Reference: PA-0004654/02
Customer reference: 2026/0342
13 August 2026

Amalgamation of two semi-detached properties to create a single dwellinghouse, with front gable extensions and dormer window; and associated alterations.

2 ST. JOHNS CLOSE BARNSELEY BARNSELEY METROPOLITAN BOROUGH S75 3RY

Environment Agency position

Proposed Ground Floor Plan
Scale 1:50

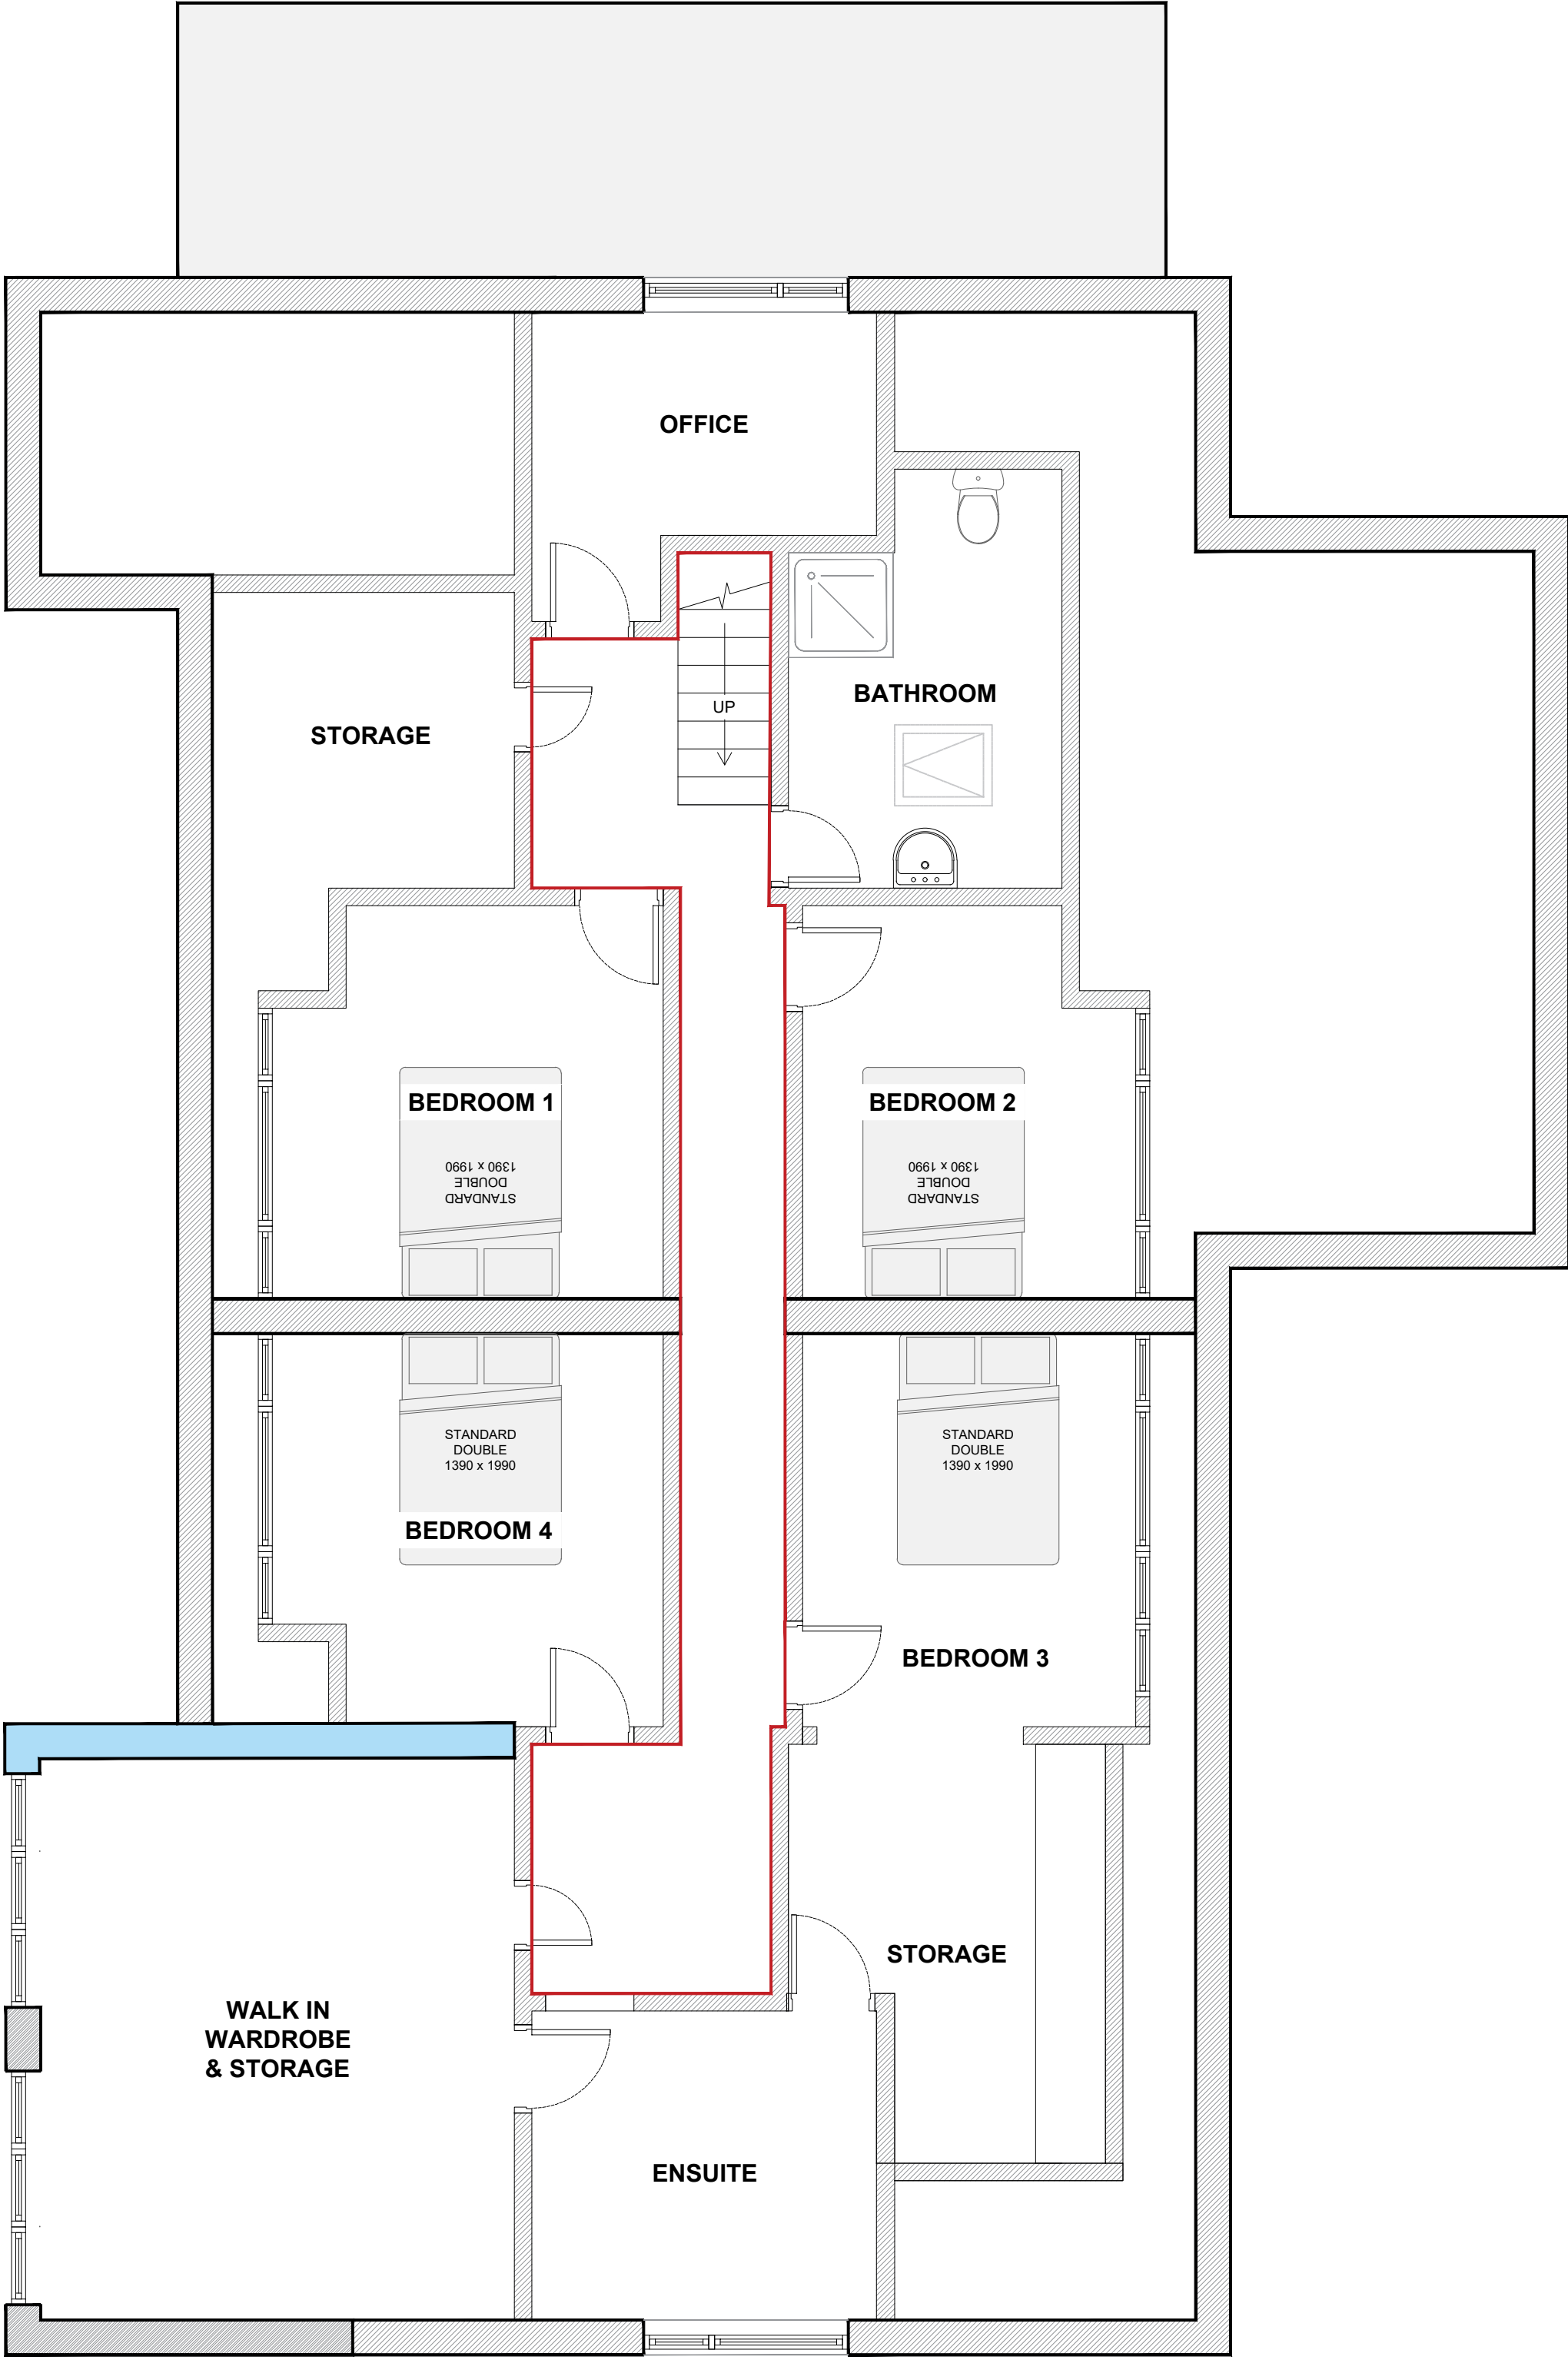
We note that the amended plans have removed the ground-floor bedroom. However, details of the existing and proposed finished floor levels in metres Above Ordnance Datum (mAOD) have not been provided. In addition, the Flood Risk Assessment should be updated to reflect the revised ground-floor layout and intended use of the accommodation and should also address the concerns raised within our previous consultation response and outstanding objection points.

To overcome our objection, the applicant should submit a revised FRA which addresses the points highlighted above.
